Ref: Planning app No: 3/2025/0385

Property affected: [REDACTED]

I would like to formally object to the above referenced planning application on the following grounds:

drawing no. SK 004	revision 0
------------------------------	----------------------

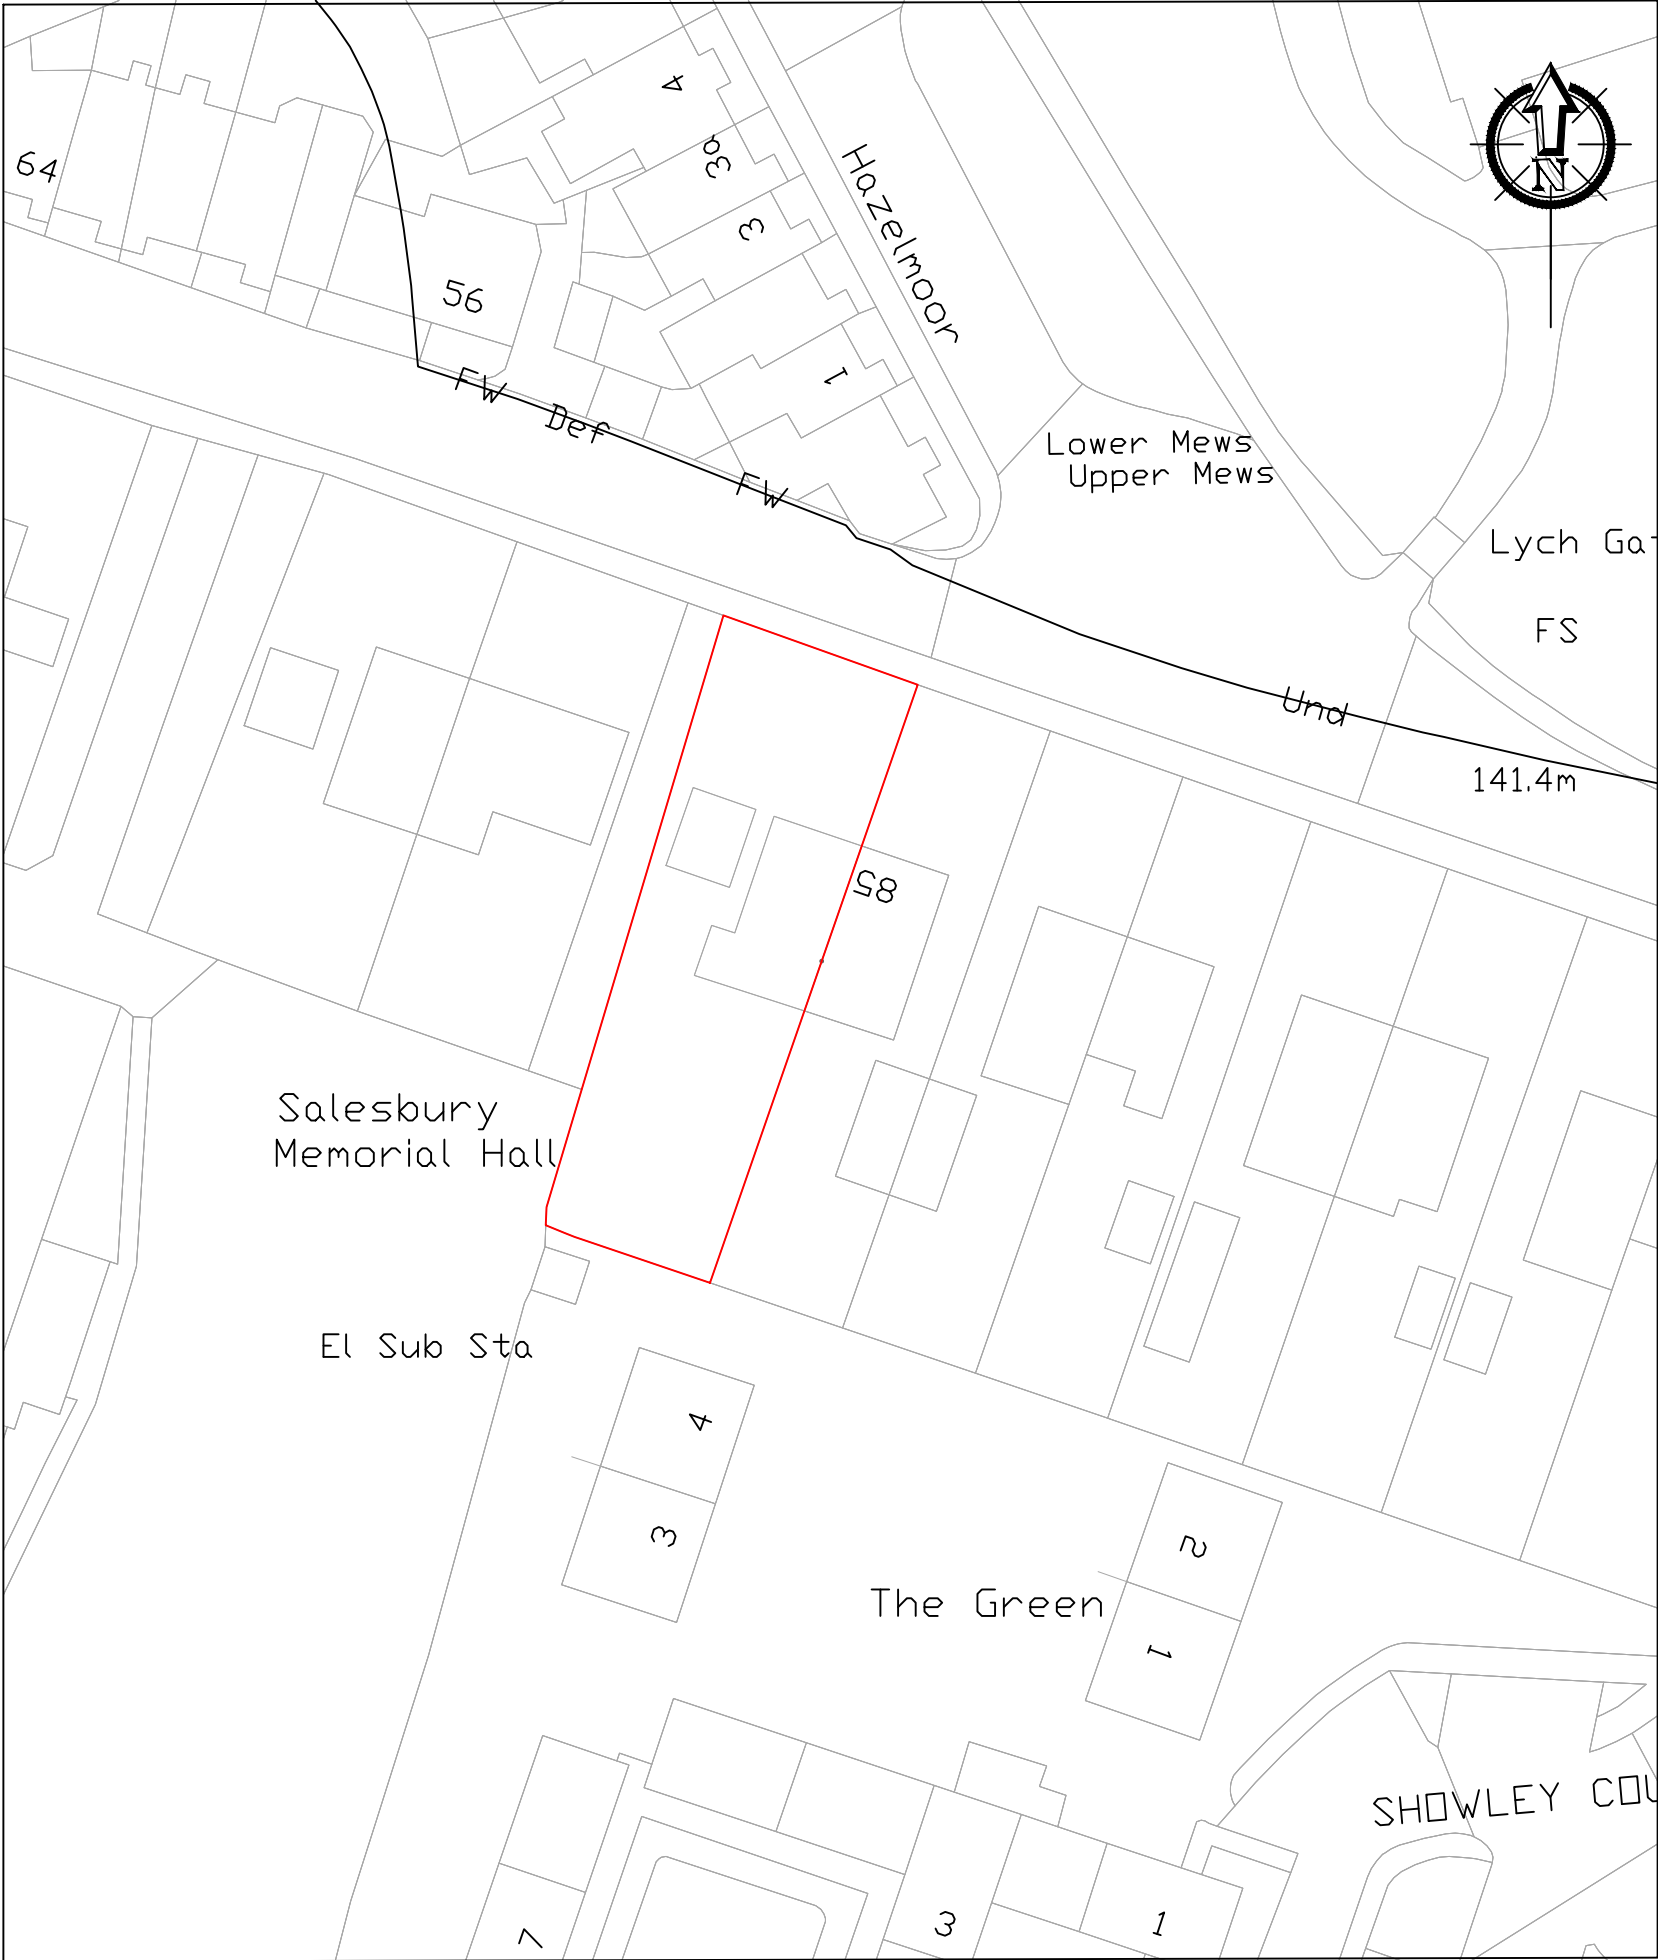
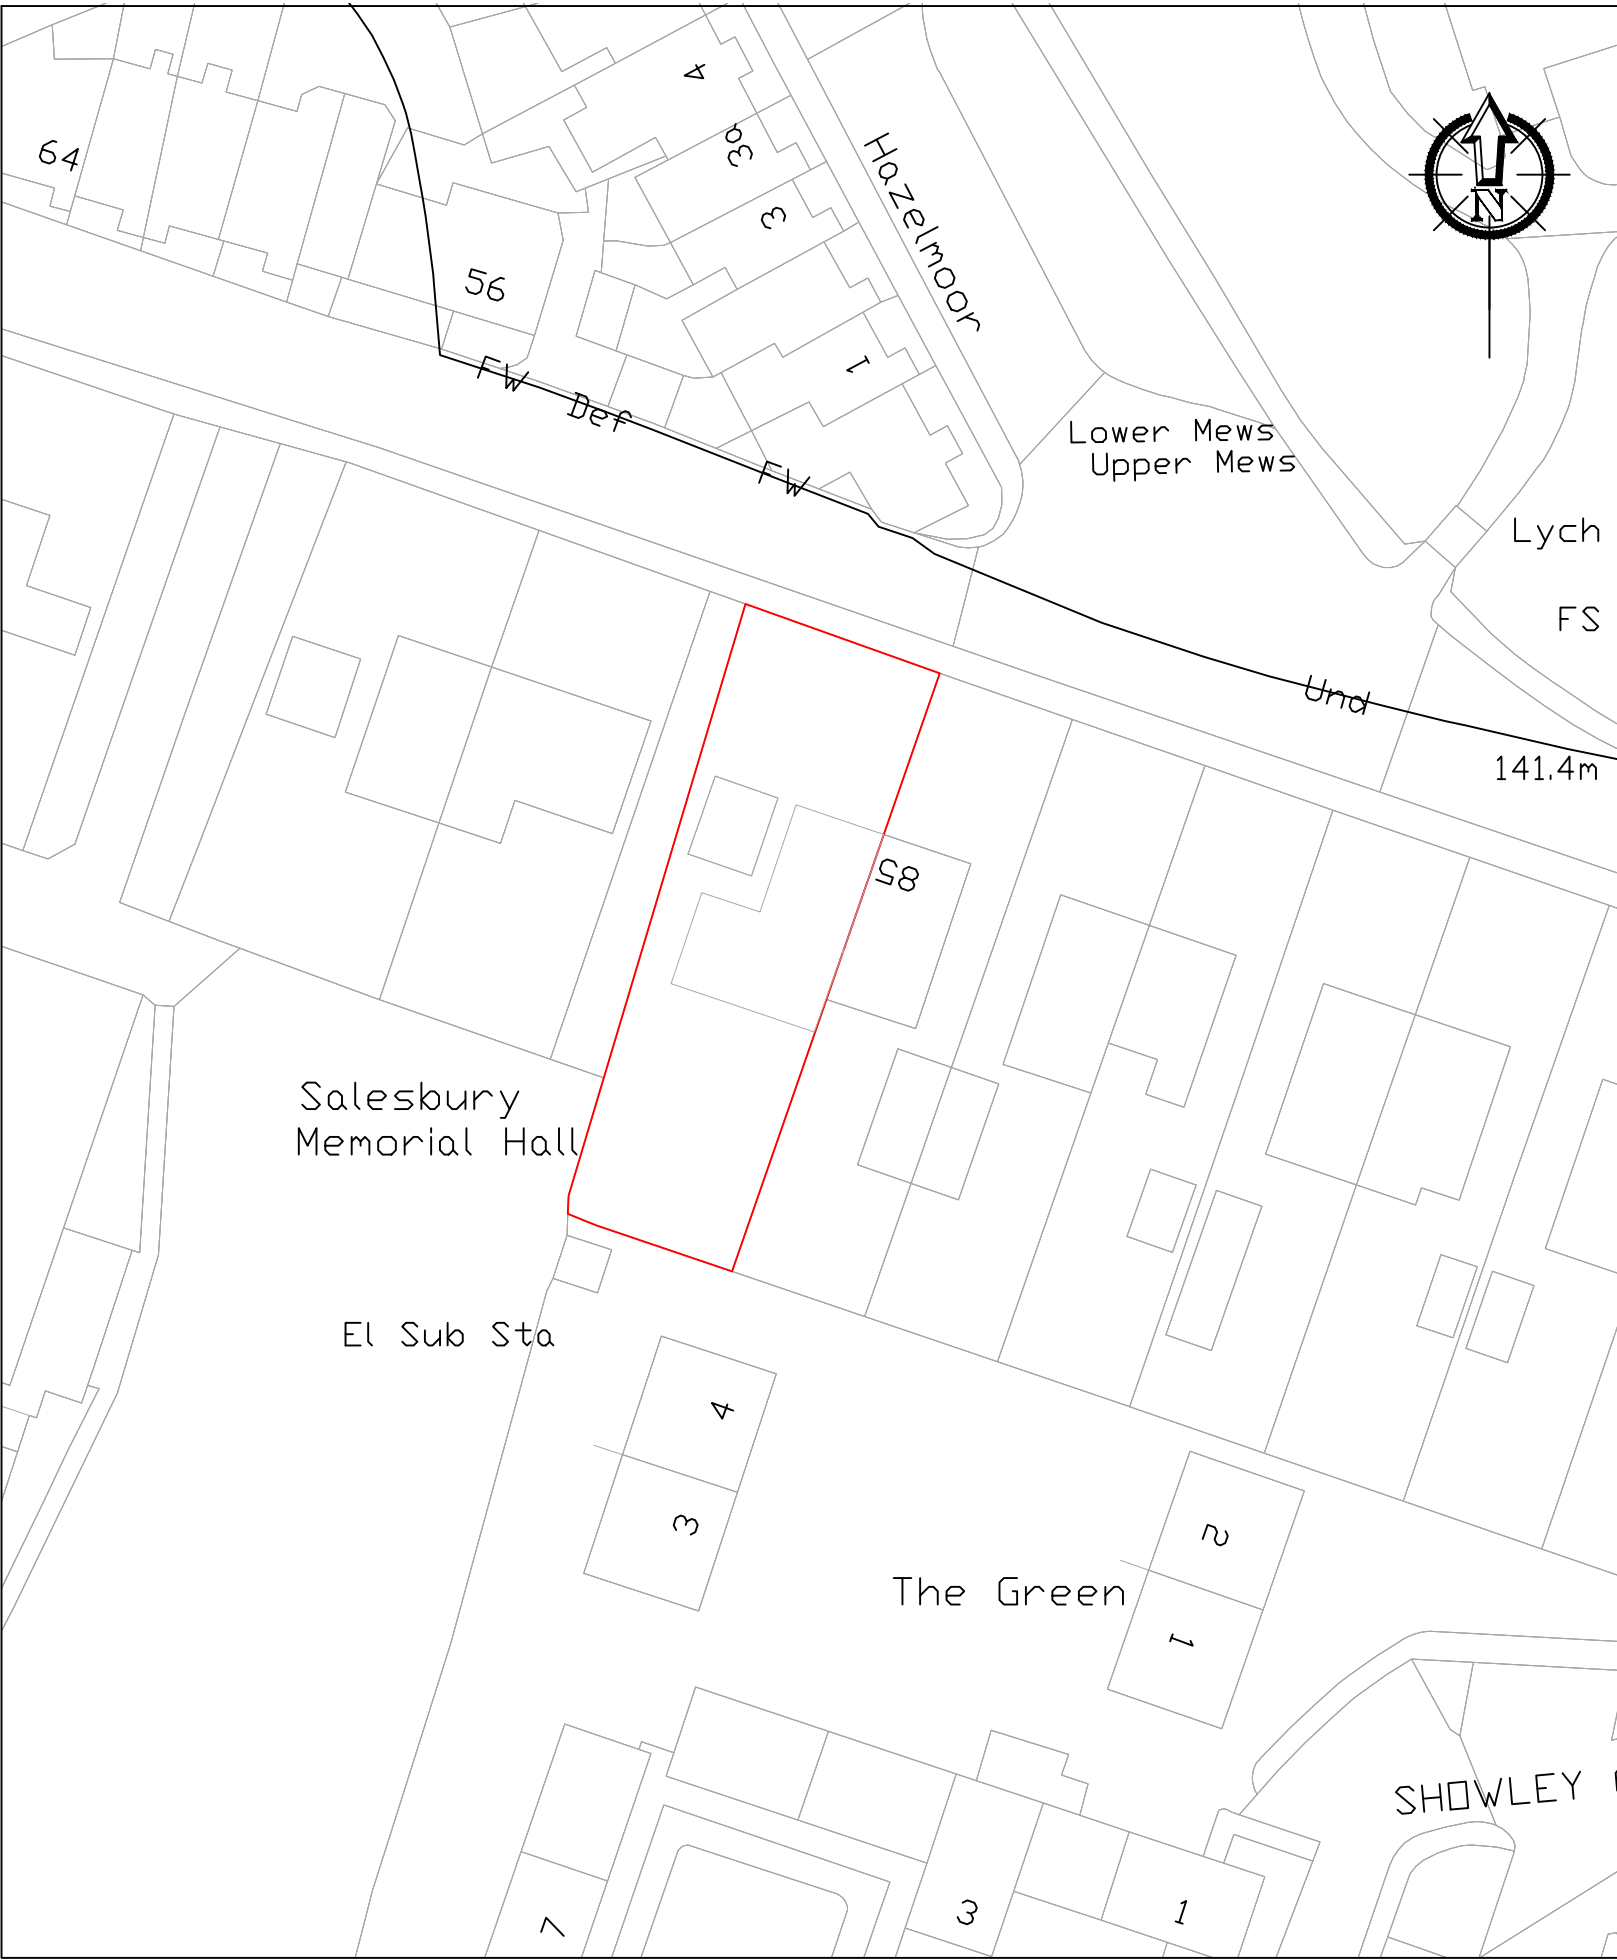
The extension exceeds the established rear building line, including extensions, of neighbouring properties, as shown in the submitted block plans SK 004.

Its scale and massing are out of keeping with the character of the area and would set an inappropriate precedent for future development

drawing no. SK 003	revision A
------------------------------	----------------------

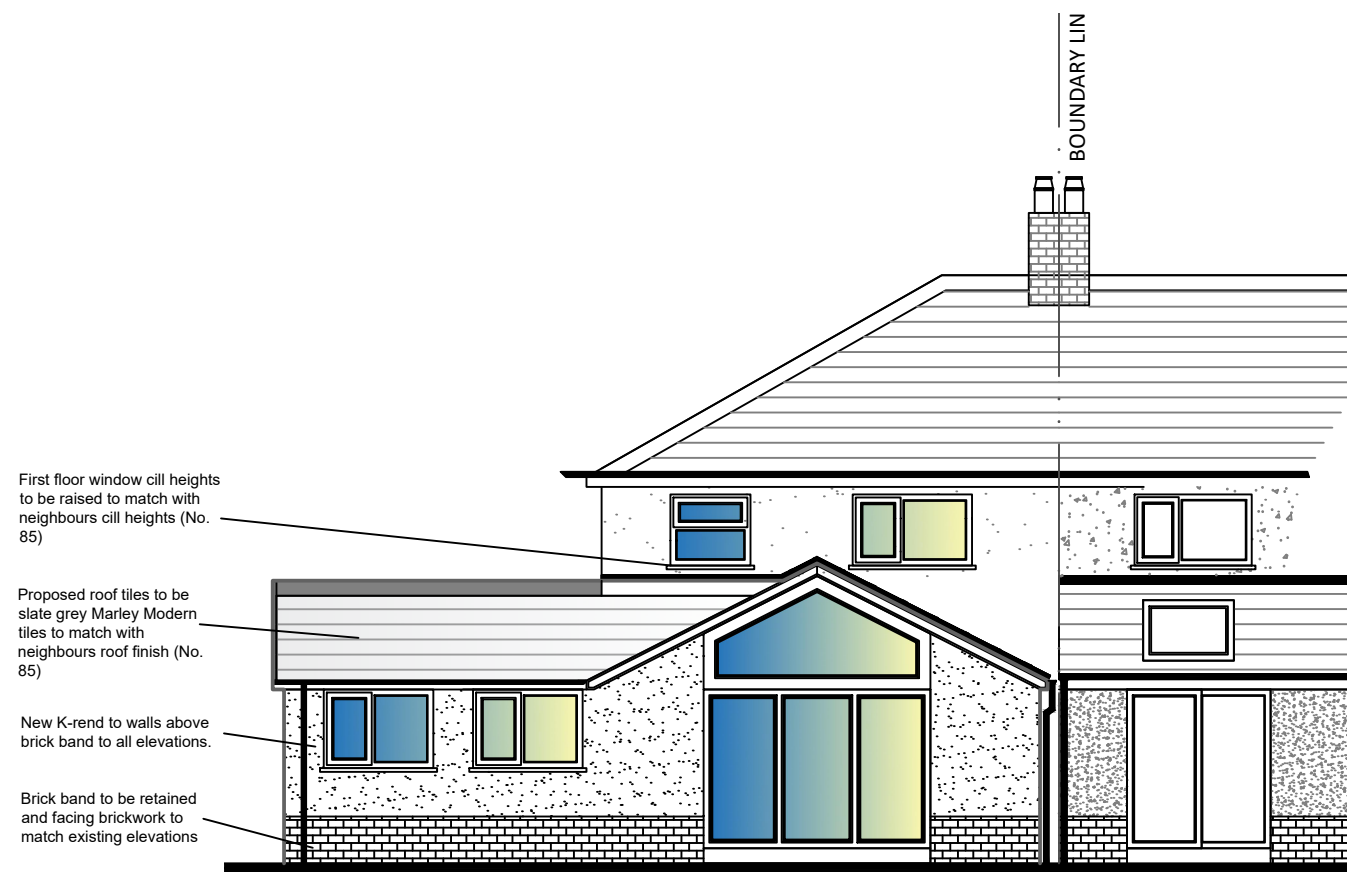
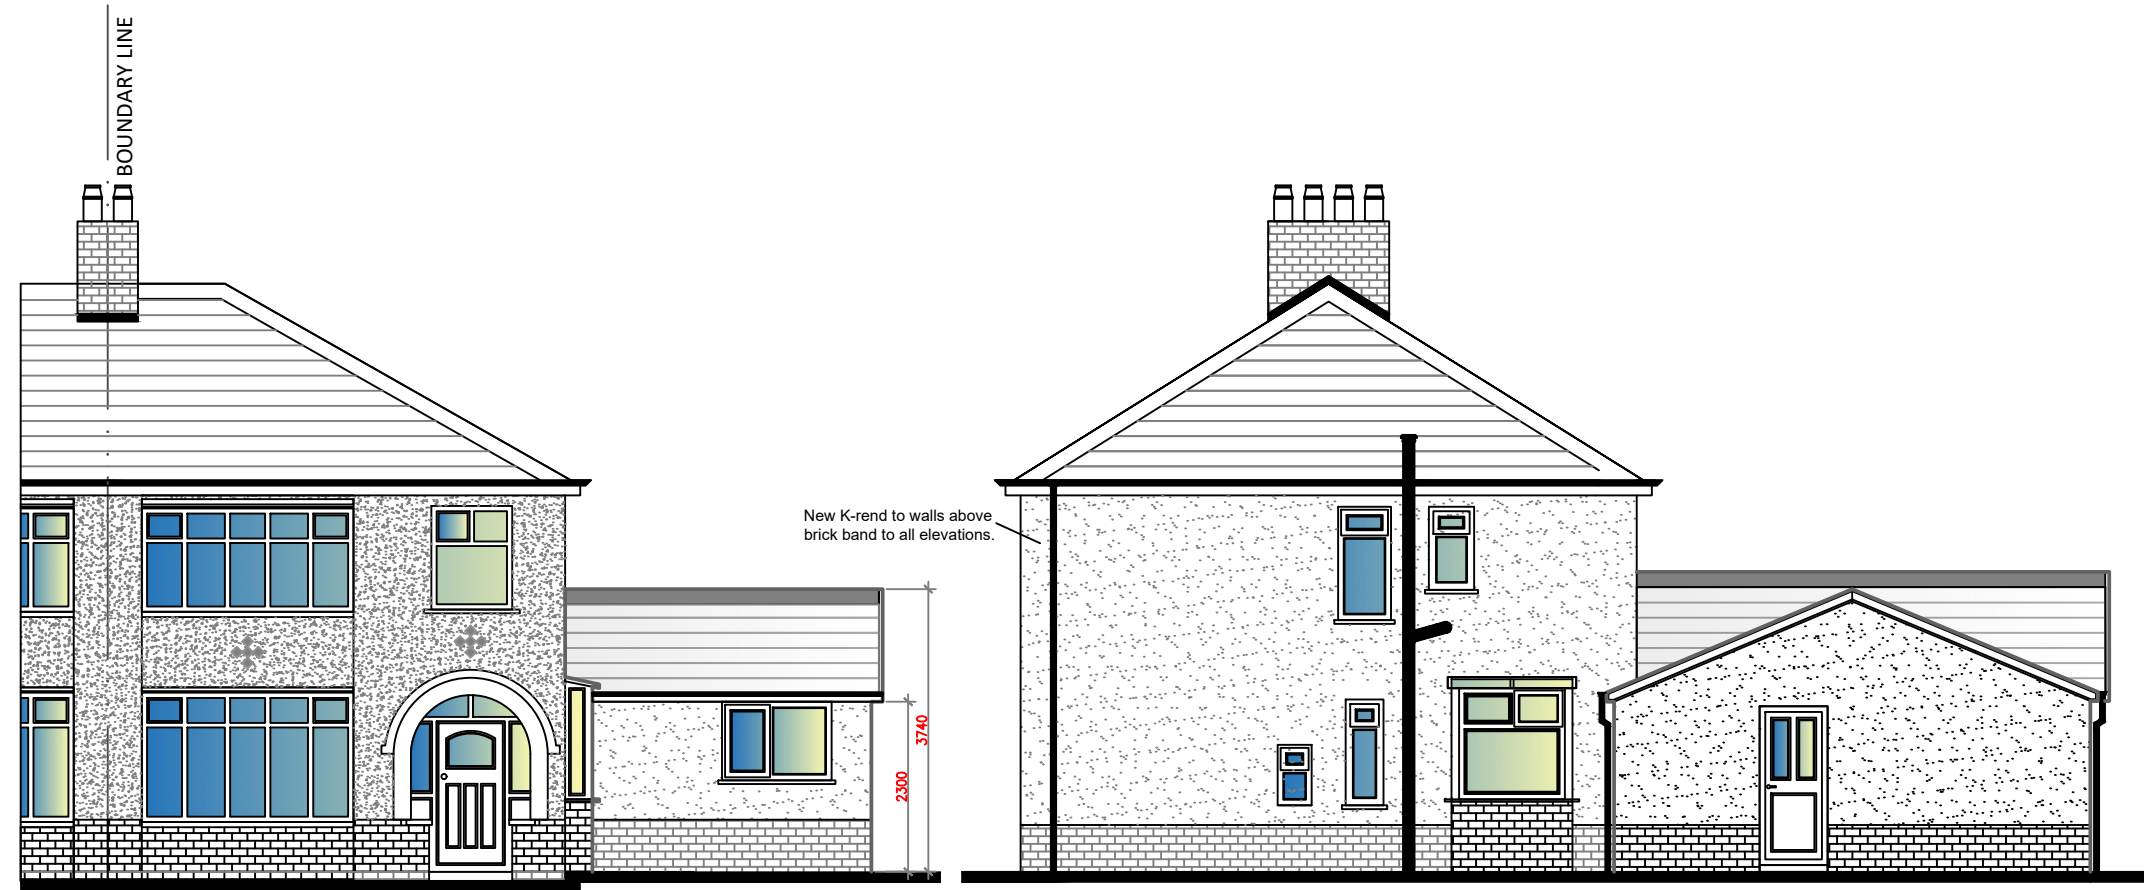
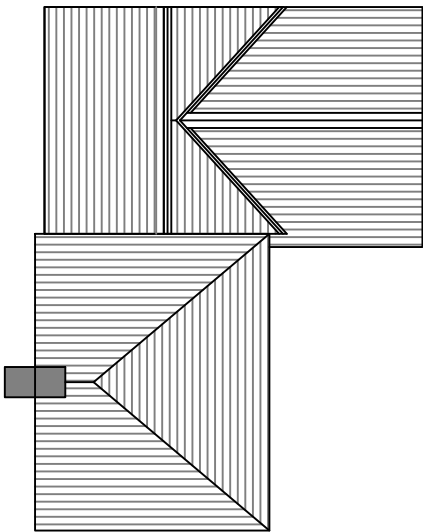
- **Submitted architectural drawing SK 003 is incorrect**

The submitted drawing incorrectly depicts the rear extension of [REDACTED] [REDACTED]
[REDACTED]

Fig 1 (attached) shows the actual arrangement. Dimensions derived from SK 003 are consequently flawed.

The extension projects a further 3 metres beyond the rear building line, [REDACTED]
[REDACTED].

Its height and proximity would create a tunnel effect, significantly reducing [REDACTED]
[REDACTED], creating a darker internal environment and increasing reliance on artificial lighting.
